**EL PASO COUNTY PLANNING AND
 COMMUNITY DEVELOPMENT
 DEPARTMENT**

GRADING AND EROSION CONTROL PLAN CHECKLIST

Revised: July 2019

DESIGNED BY:	CP	SCALE	DATE ISSUED:	DECEMBER, 2020	DRAWING No.
DRAWN BY:	TS	HORIZ 1"=100'	SHEET	4 OF 9	GEC01
CHECKED BY:	NS	VERT. N/A

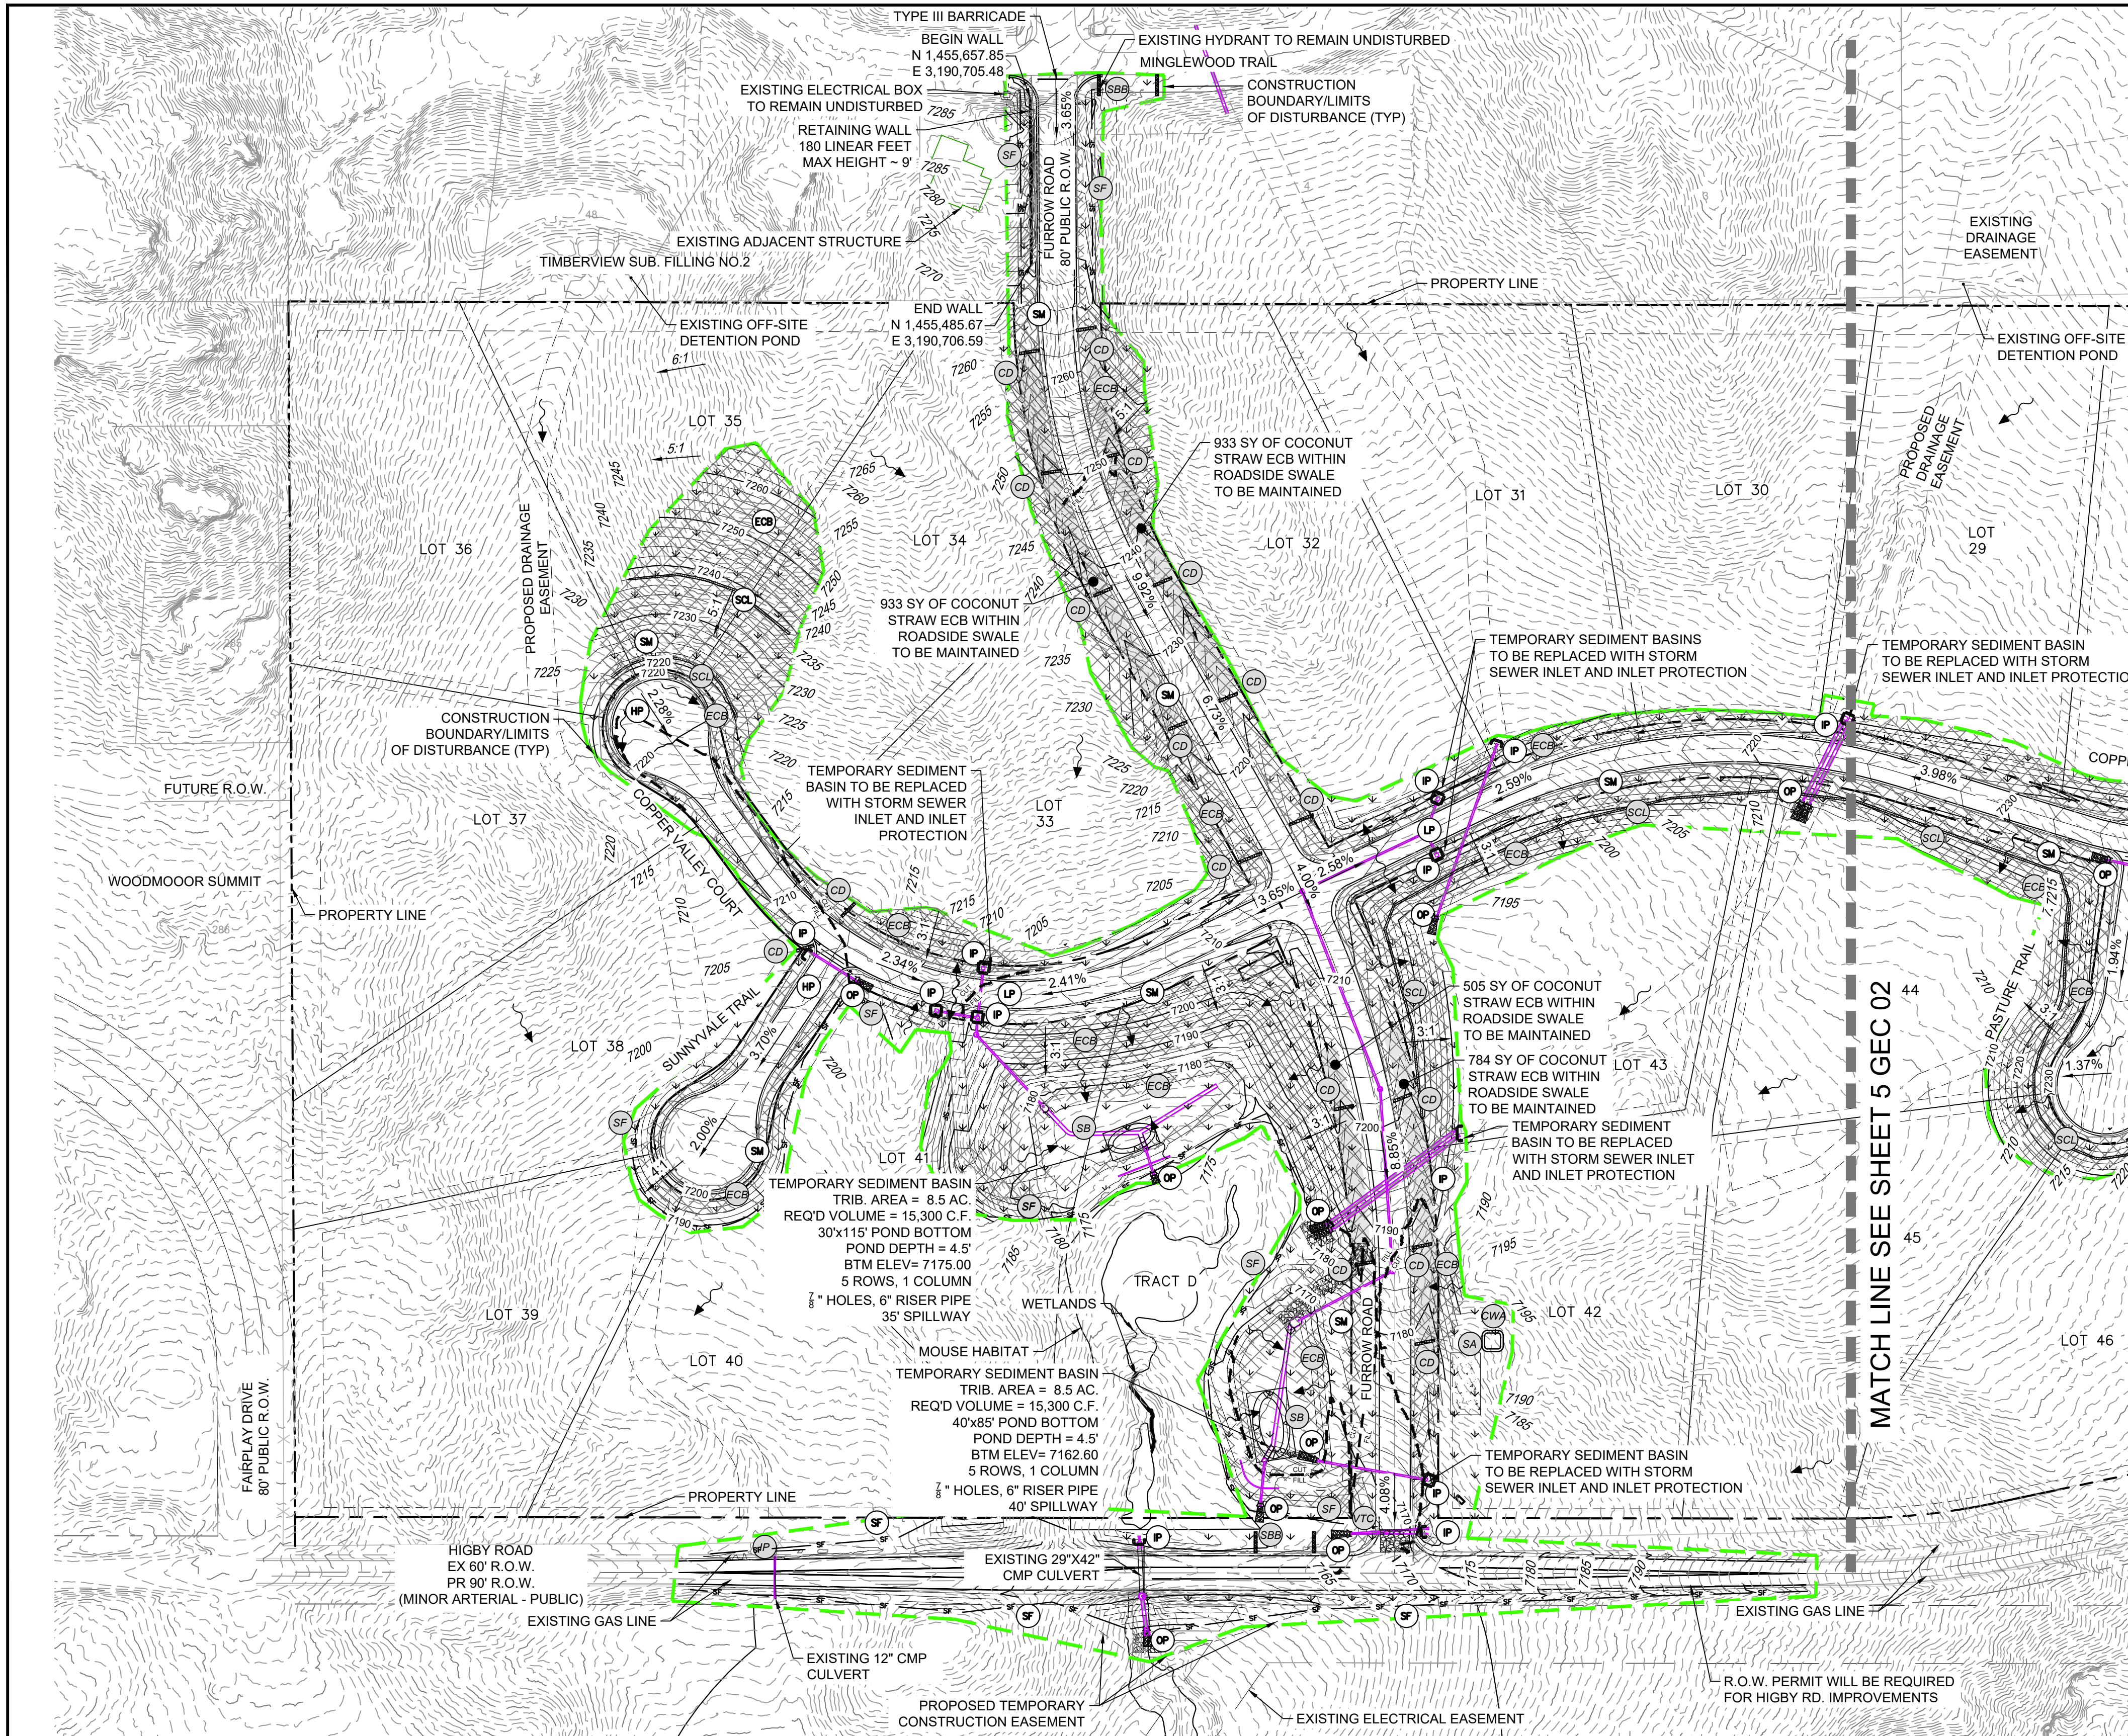
v	All proposed temporary construction control measures, structural and non-structural. Temporary construction control measures shall be identified by phase of implementation to include "initial," "interim," and "final" or shown on separate phased maps identifying each phase.	Y	X
w	Vehicle tracking provided at all construction entrances/exits. Construction fencing, barricades, and/or signage provided at access points not to be used for construction.	Y	✓
x	Temporary sediment ponds provided for disturbed drainage areas greater than 1 acre.	Y	✓
y	Dewatering operations to include locations of diversion, pump and discharge(s) as anticipated at time of design.	N/A	N/A
z	All proposed temporary construction control measure details. Custom or other jurisdiction's details used must meet or exceed EPC standards.	Y	✓
